Appeal Decision

Appeal Ref: APP/R4408/D/19/3226422

20 Gilder Way, Shafton, Barnsley, S72 8WP

PROPOSED ELEVATIONS

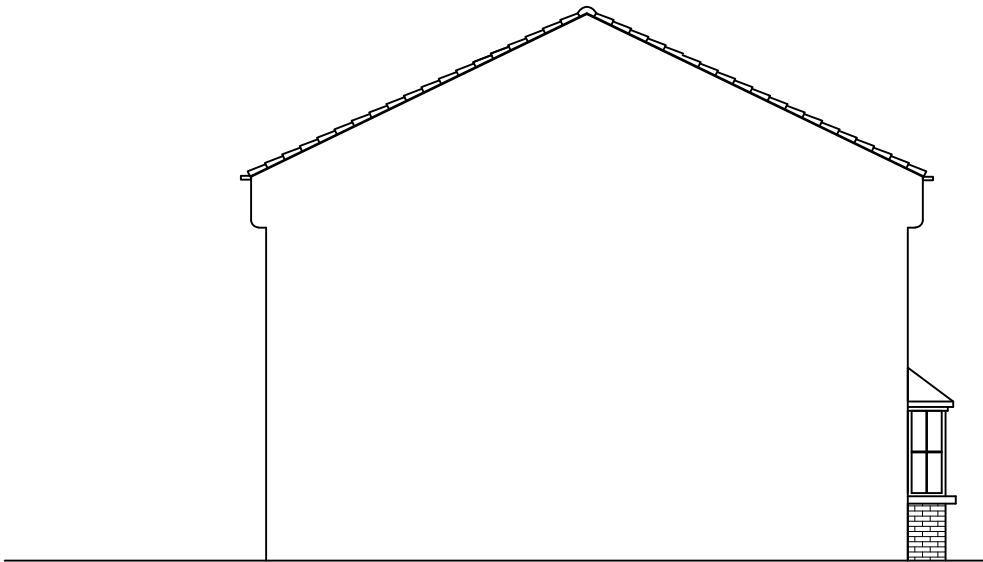
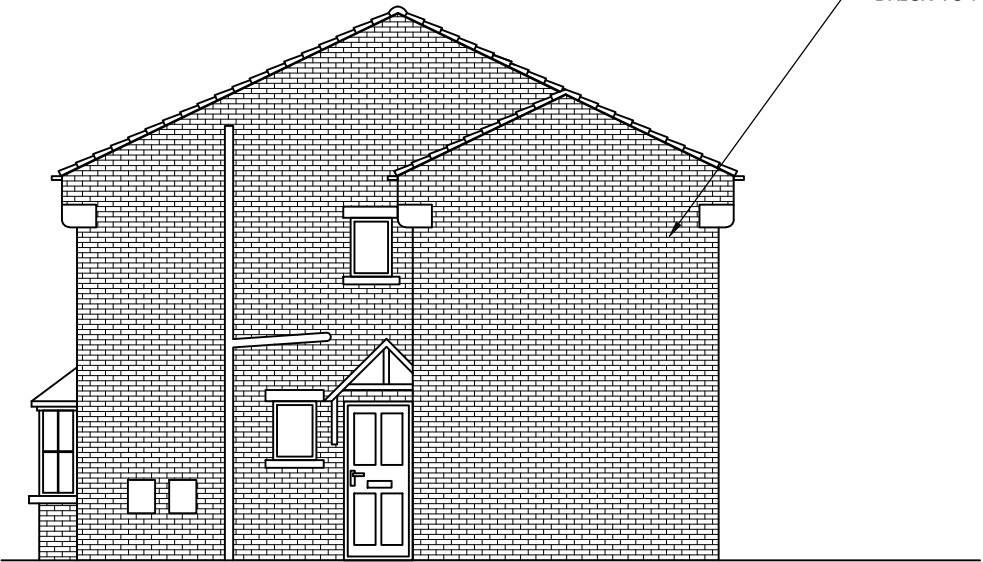
6. The proposal is to build a two-storey extension upon the side elevation, which would cover half of the length of the gable and project to the western boundary of the property, while maintaining the existing blank wall. A window and roller shutter door are proposed upon the front elevation of the extension, with further fenestration at ground and first floor level to the rear. The facing brick of the walls and roof tiles would match those of the existing, while the roof would be set below the height of the host property while maintaining the pitched appearance.

7. The appeal site occupies a corner plot and the extension would be prominent in the streetscene when travelling along Gilder Way. A small area of garden space exists to the side of the appeal property, which is rare within this area and serves to alleviate some of the feeling of densely packed built form when travelling through the estate. This is exacerbated by the lack of off-street parking available for the terraced housing, as cars line the road along Gilder Way. The space therefore makes a significant, positive contribution to the character and appearance of the surrounding area.

8. The National Planning Policy Framework 2019 (The Framework) sets out the government's aim of achieving well designed places and refers to the need to ensure that development should, amongst other things, add to the overall quality of the area. Providing more detailed guidance, the SPD advises that two-storey side extensions on corner plots should not fill more than half of the gap between the side elevation of the original dwelling and the property's side boundary. The extension would essentially fill this gap entirely, contrary to guidance. Given its location and resulting erosion of open space, especially when turning into the cul-de-sac from Gilder Way, it would not contribute positively to the area and would appear intrusive.

SITE PLANS

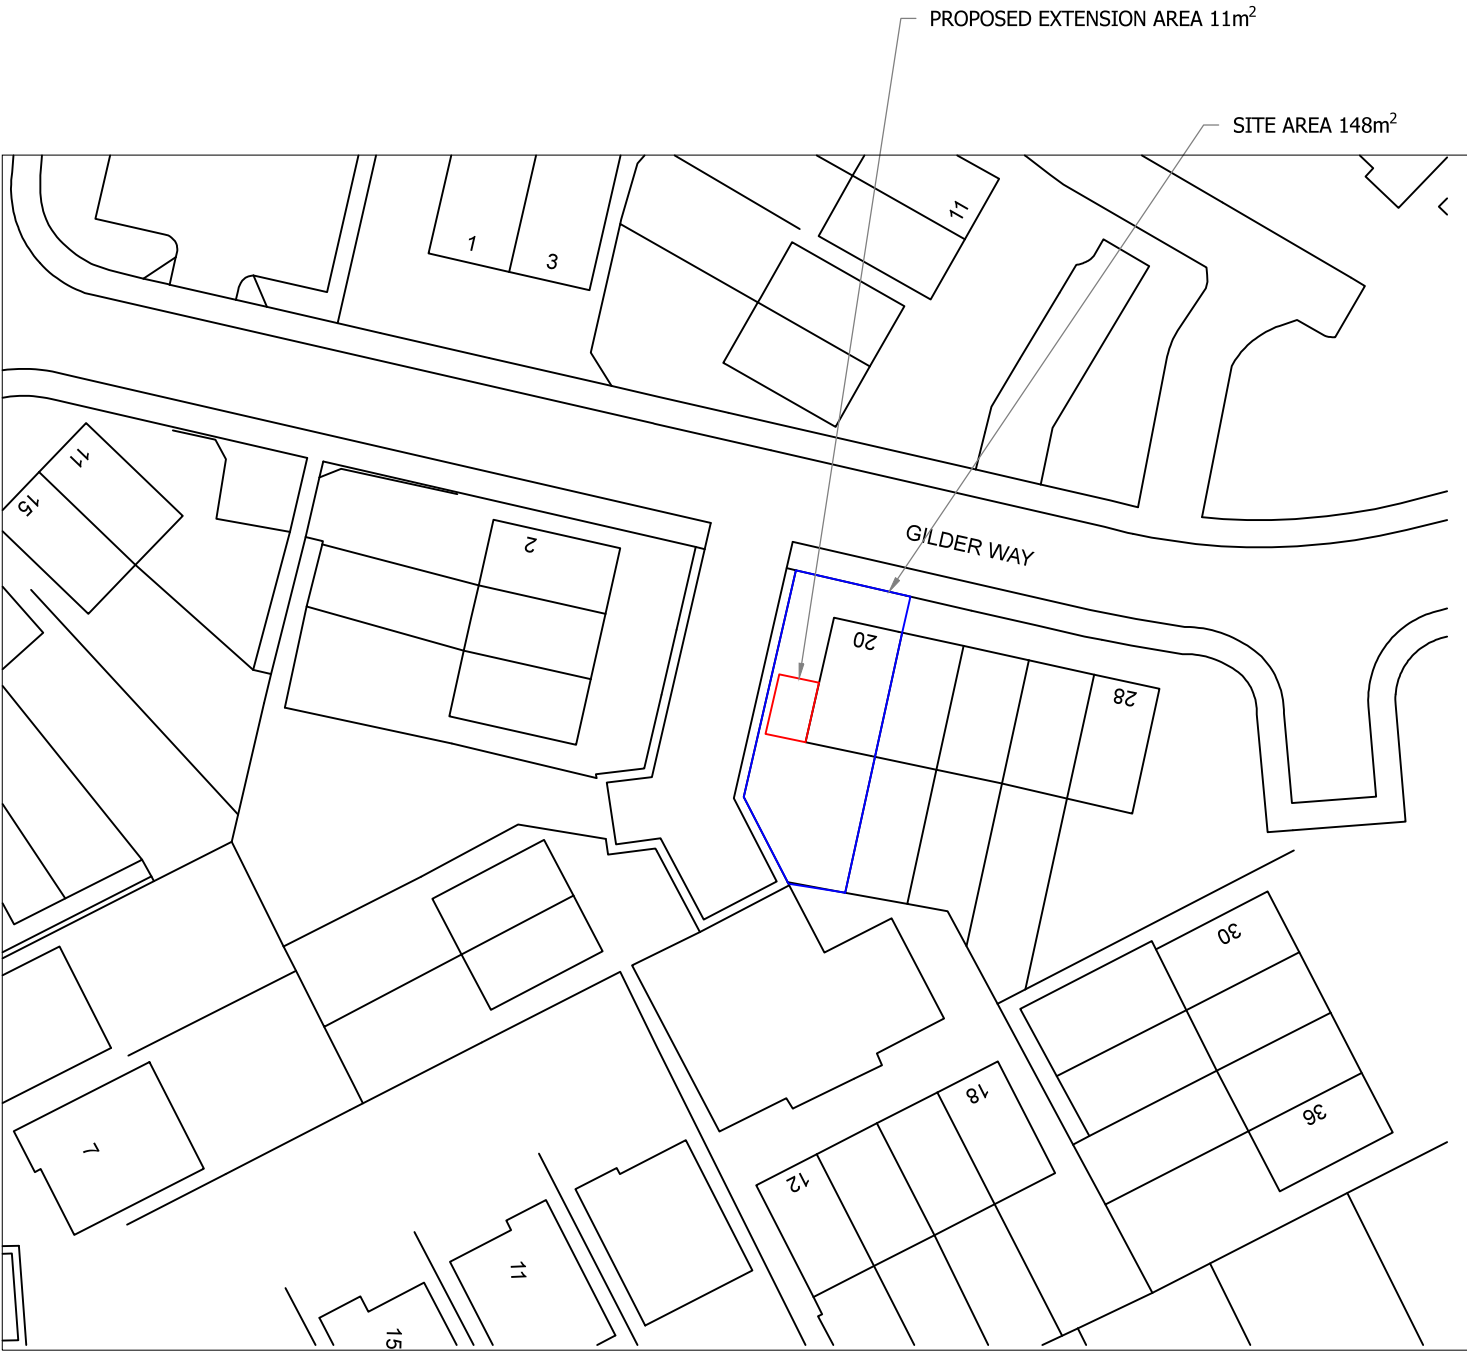
10. The extension would project from its gable end towards the front elevation of a row of 3 terraced houses located to the other side of the junction of Gilder Way and the cul-de-sac. The officer report references a 12m distance as being 'normally accepted', but a judgement is still required as to the impact of these works.
11. The extension would project towards habitable rooms, but the facing wall would maintain its blank façade and only covers half of this elevation. I am satisfied this would not lead to an overbearing impact upon the occupiers of the adjacent row of dwellings that would affect their outlook negatively. Accordingly, I find the proposal to be in accordance with policy D1 of the LP and relevant provisions of the SPD with regards to living conditions.
